**From:** [Alder, David](#)  
**To:** [David](#)  
**Cc:** [dillon5@bigpond.com](mailto:dillon5@bigpond.com); [Penny Dixon](#); [Airspace Protection](#)  
**Subject:** RE: F17/7649-38 Request for Feedback - Proposed Tangaratta Poultry Feedmill - 771 Wallamore Road, Tamworth. CASA Comments to PSA Consulting [SEC=OFFICIAL]  
**Date:** Friday, 6 December 2024 11:54:02 AM  
**Attachments:** [image001.png](#)  
[image002.png](#)

**Subject:** Request for Feedback - Proposed Poultry Feedmill - 771 Wallamore Road, Tamworth.

PSA Consulting (Australia) Pty Limited has been engaged by Tangaratta Stockfeeds (part of the Baiada Group of Companies) to prepare an Environmental Impact Statement (EIS) for the new poultry feed mill located on land at 771 Wallamore Road, Wallamore NSW.

SECTION A-A
NORTH-WEST ELEVATION
1 : 400

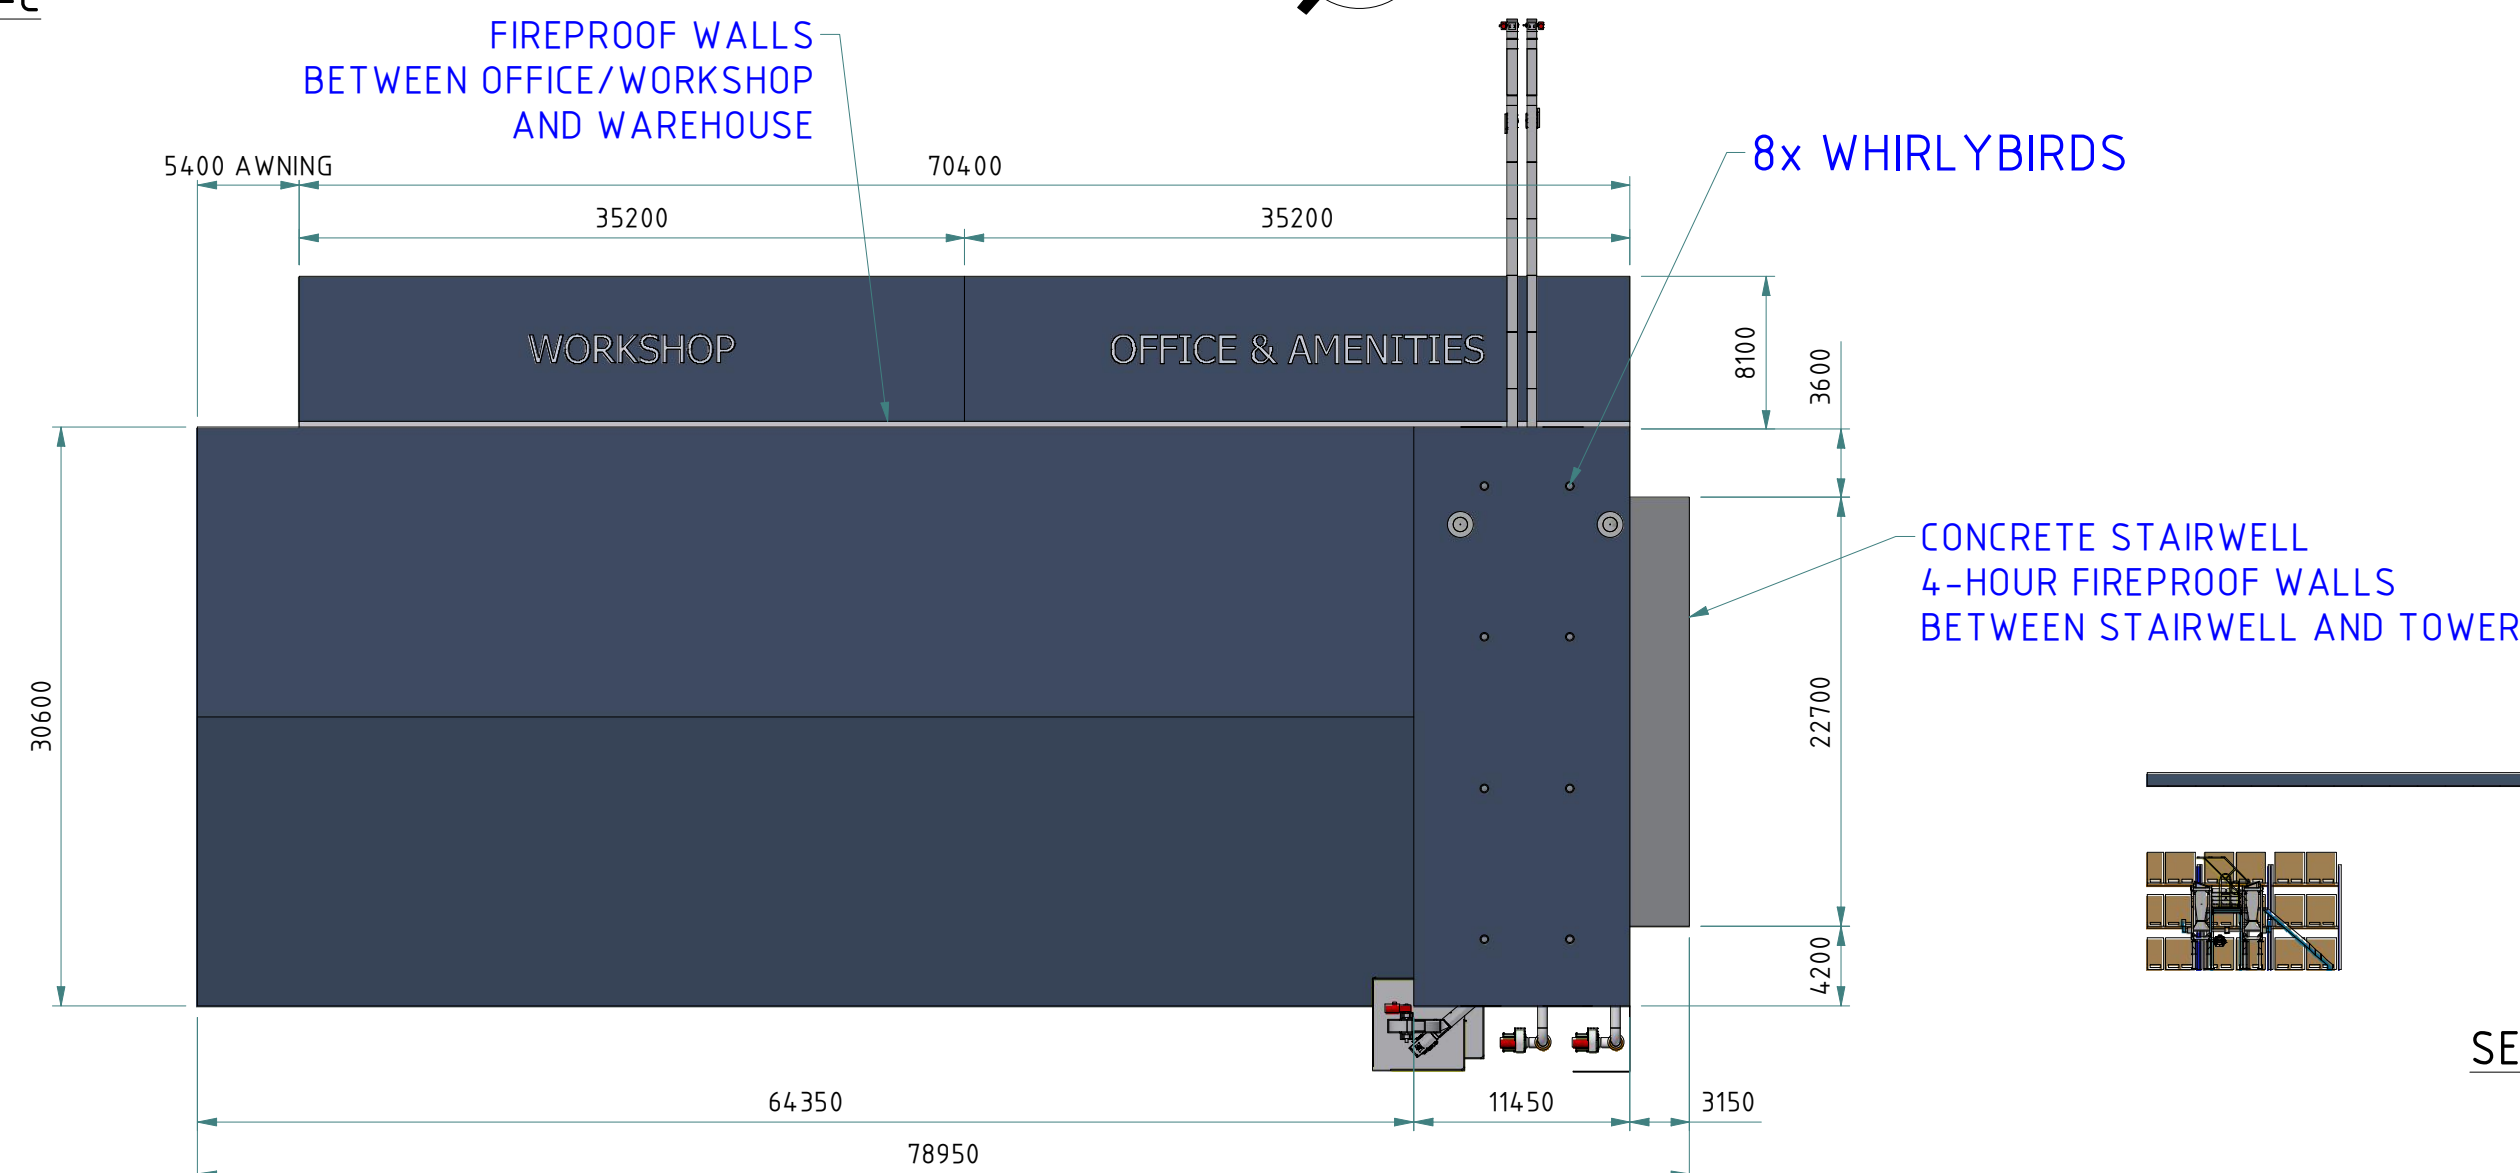
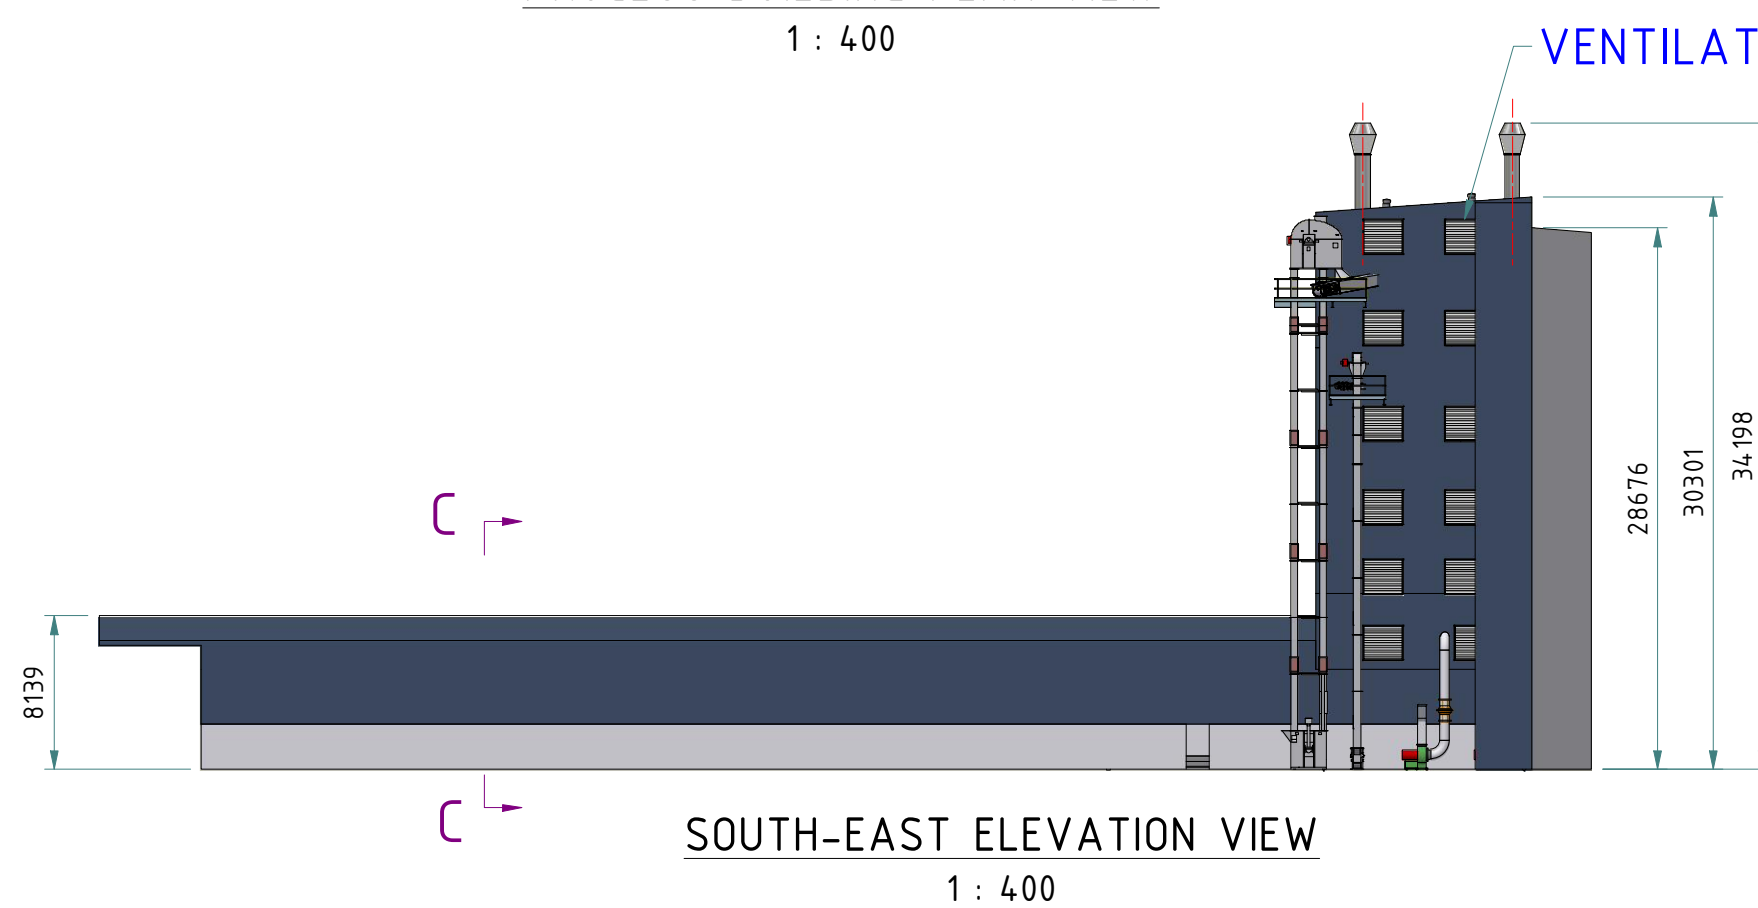
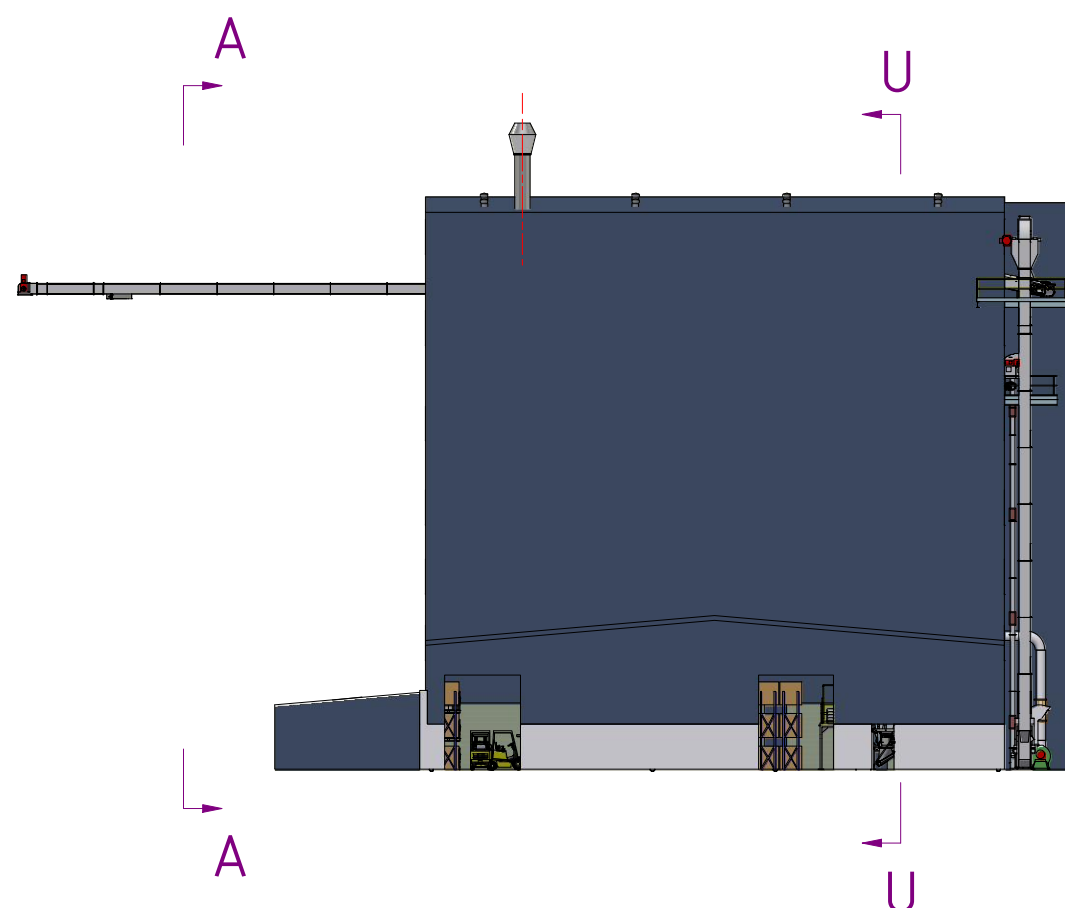
Using first principles. The drawings indicate that the stack height is about 37m Above ground level. The land is about 378m above AHD making a total of about 425m above AHD. Runway 18/36 is Code 2. The Approach slope only extends 2.5km. The stacks will be under the Obstacle Limitation Surfaces (Inner Horizontal Surface) ... by very roughly 15 - 20m (could be confirmed by the Airport – I don't have an authoritative OLS diagram). As there will not be any OLS infringements, CASA does not need to perform an obstacle assessment. There would be no need for obstacle lighting or marking. Also, as the process is not super heat / exhaust intensive, there is no need for a plume rise assessment.
